Shear Design
2 Saffron Close
Shoreham By Sea
BN43 6JF

Our Ref: CM/45/21/NMA

Non-material amendment following grant of CM/16/21/PL for the installation of a new flower wall to the side elevation

Bairds Farm Shop Crookthorn Lane Climping BN17 5SN

| NORTH                                | 21/24            | PL1            | C         |            |          |

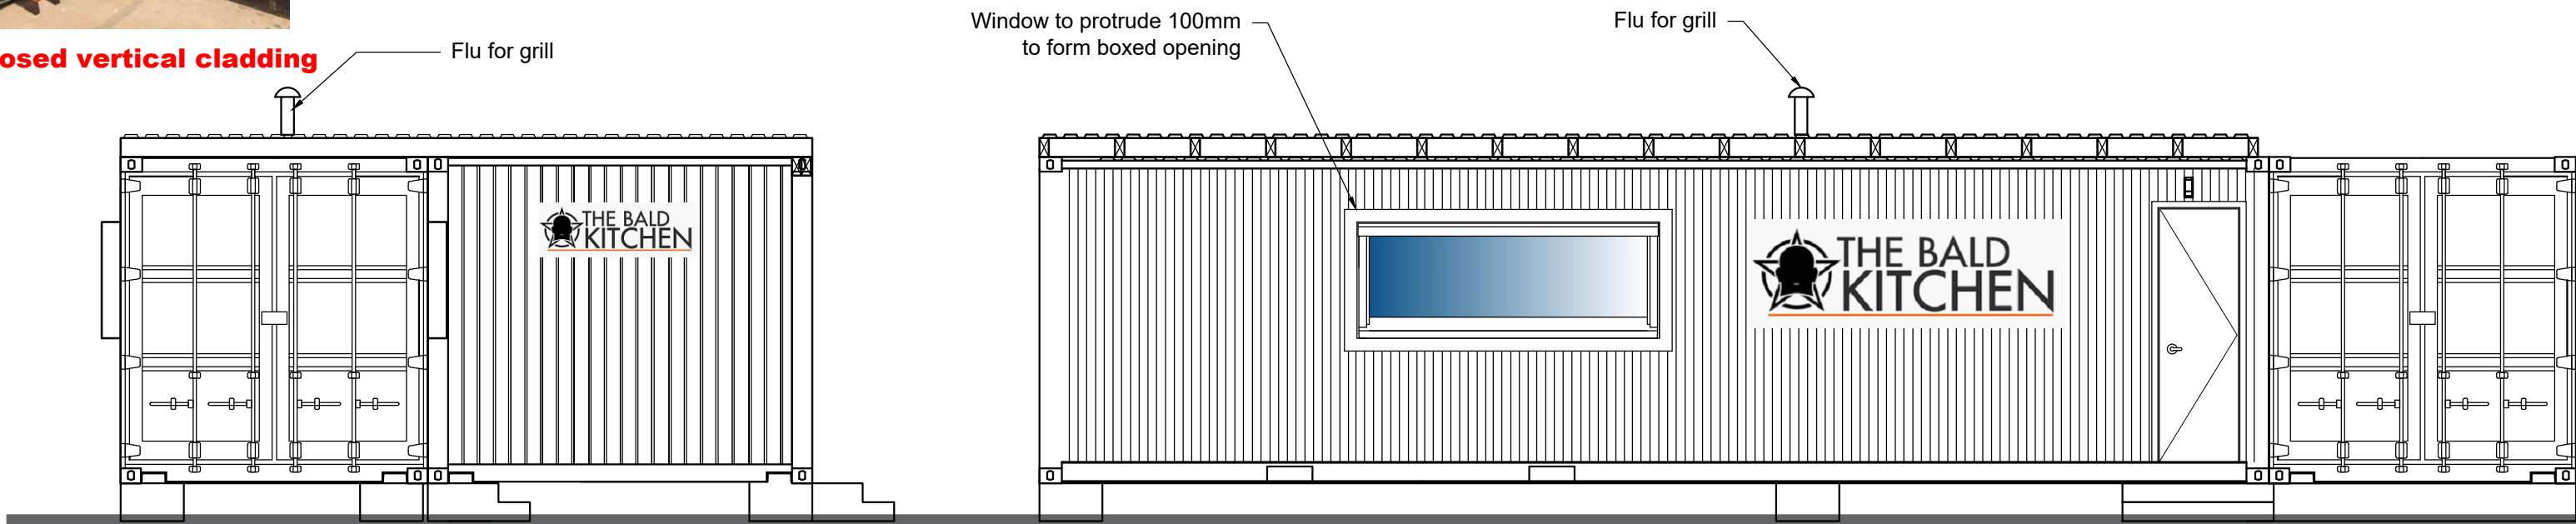
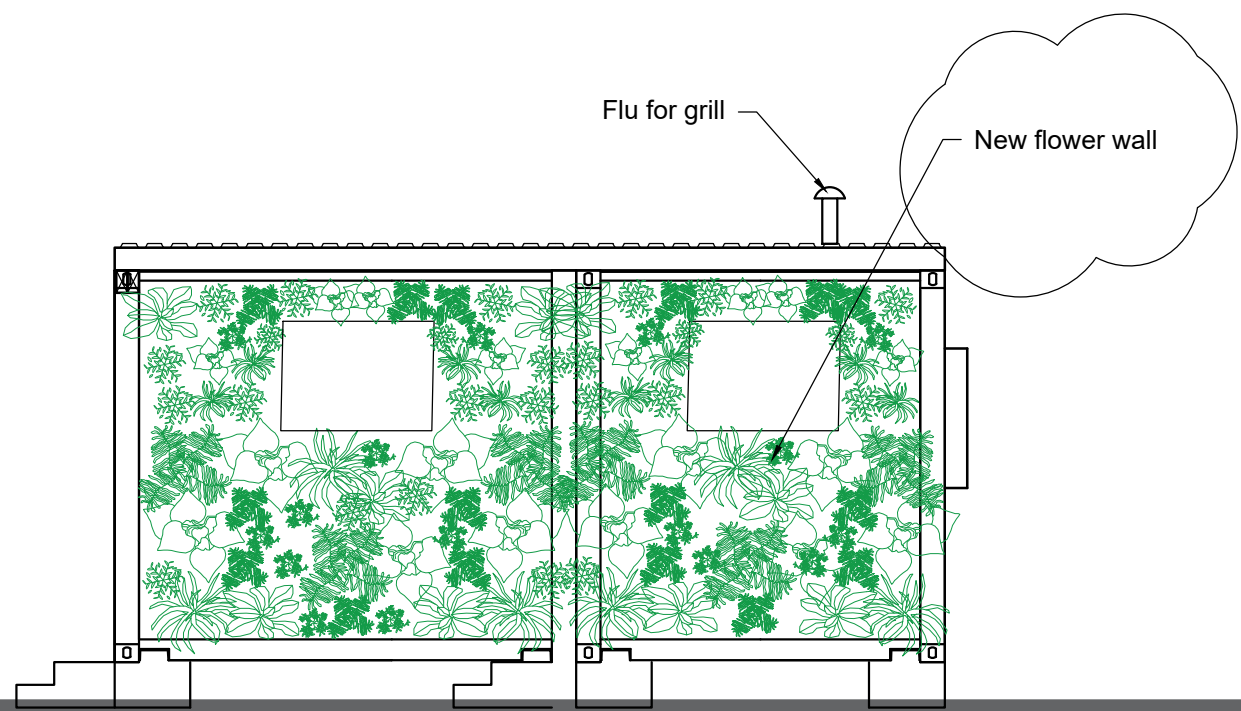
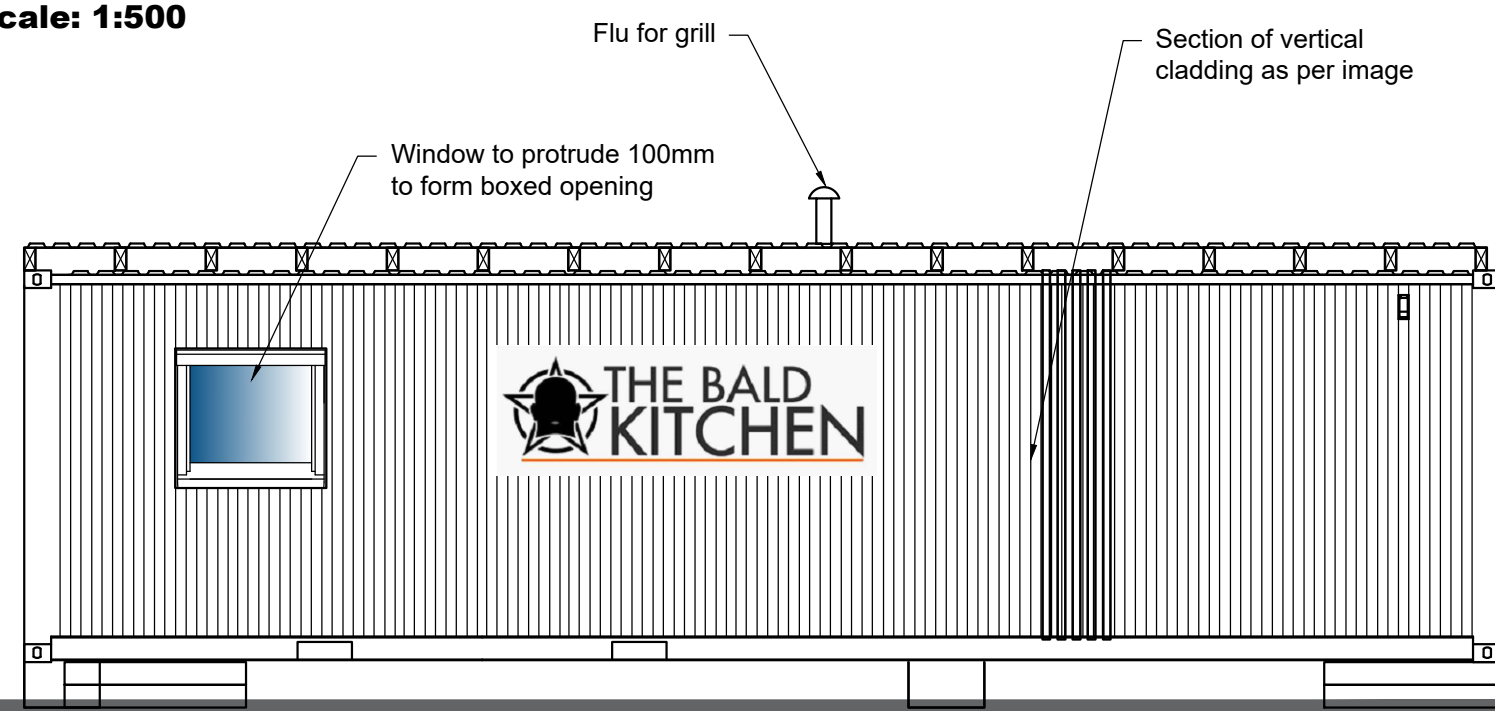
From the information submitted I am able to take the alterations to provide a flower wall to the north side elevation of the structure as a Minor Amendment to planning permission CM/16/21/PL. The previously approved drawing number 21/24 - PL1 rev B has been replaced by drawing number 21/24 - PL1 rev C which details the changes to the Block and Side (north) Elevation only. For clarity, this application only relates to the provision of the flower wall.
